KITITAS COUNTY

MEMORANDUM

TO: All Staff
FROM: Justin Turnbull, County Surveyor 
DATE: May 11, 2017
SUBJECT: County Survey Review of Preliminary Plat LP-17-00005 (Trailhead)

KITITAS COUNTY		WASHINGTON
DWN BY	DATE	JOB NO.
DLP	3/2017	16080
CHKD BY	SCALE	SHEET
GW	1" = 300'	1 OF 3

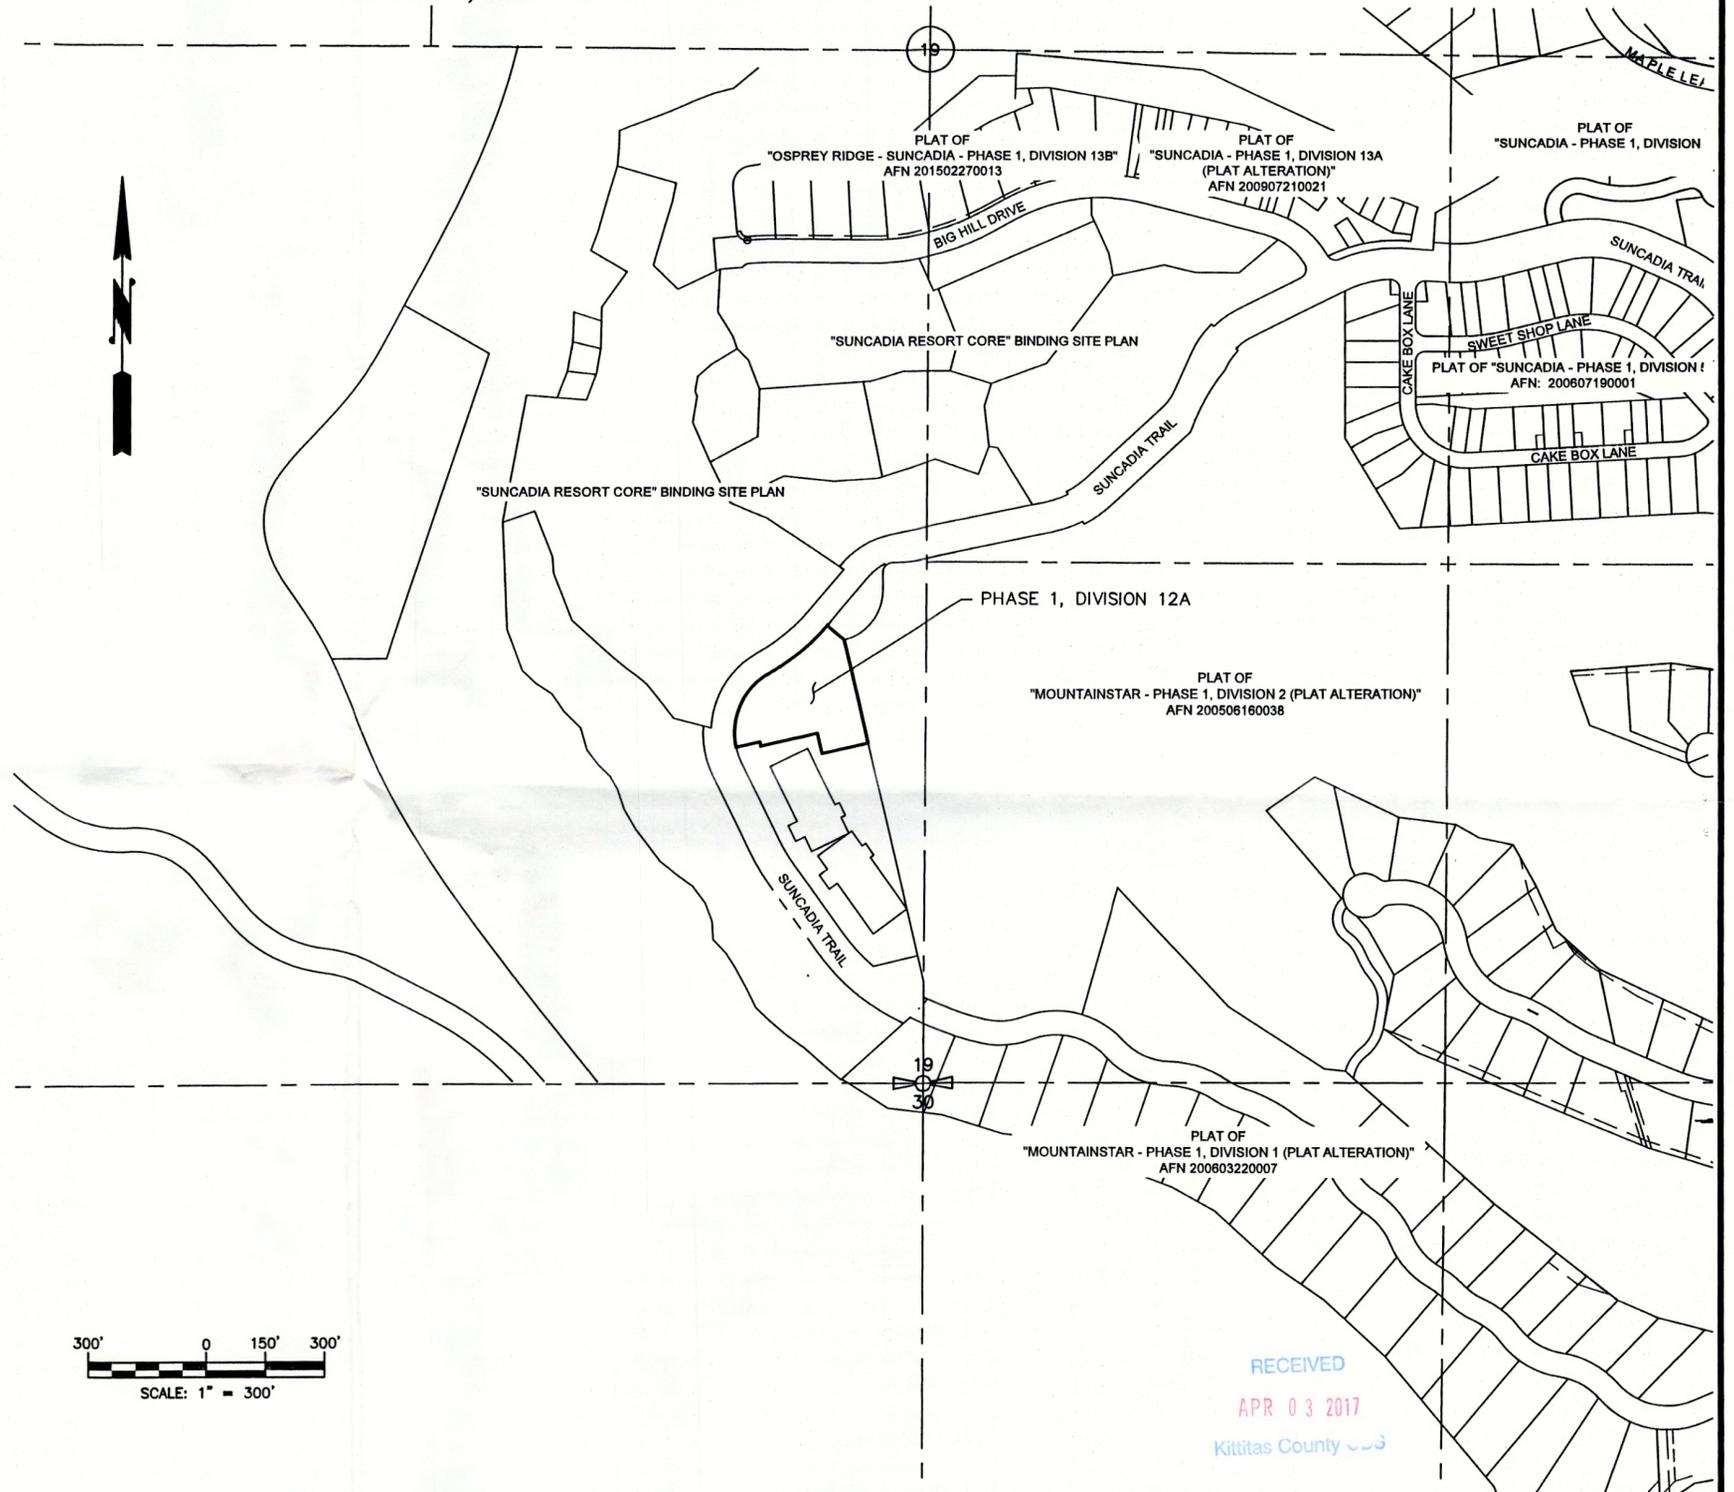
1. Surveyor Certificate, survey stamp, and surveyor name missing from plat.
2. The Legend is missing from the plat.
3. No ties to permanent monuments shown. (KCC16.24.010)
4. The plat does not show 3 durable distinctive reference points or monuments. (KCC16.24.010)
5. The plat does not include sufficient data to determine the bearing and length of each line. (KCC16.24.010)
6. The Text "Lot 4" next to Lot "4" is misleading, particularly if subsequent surveys reference Lot 4 or this Plat. It is suggested to replace "Lot 4" with "Lot 4 - Suncadia Phase 1"
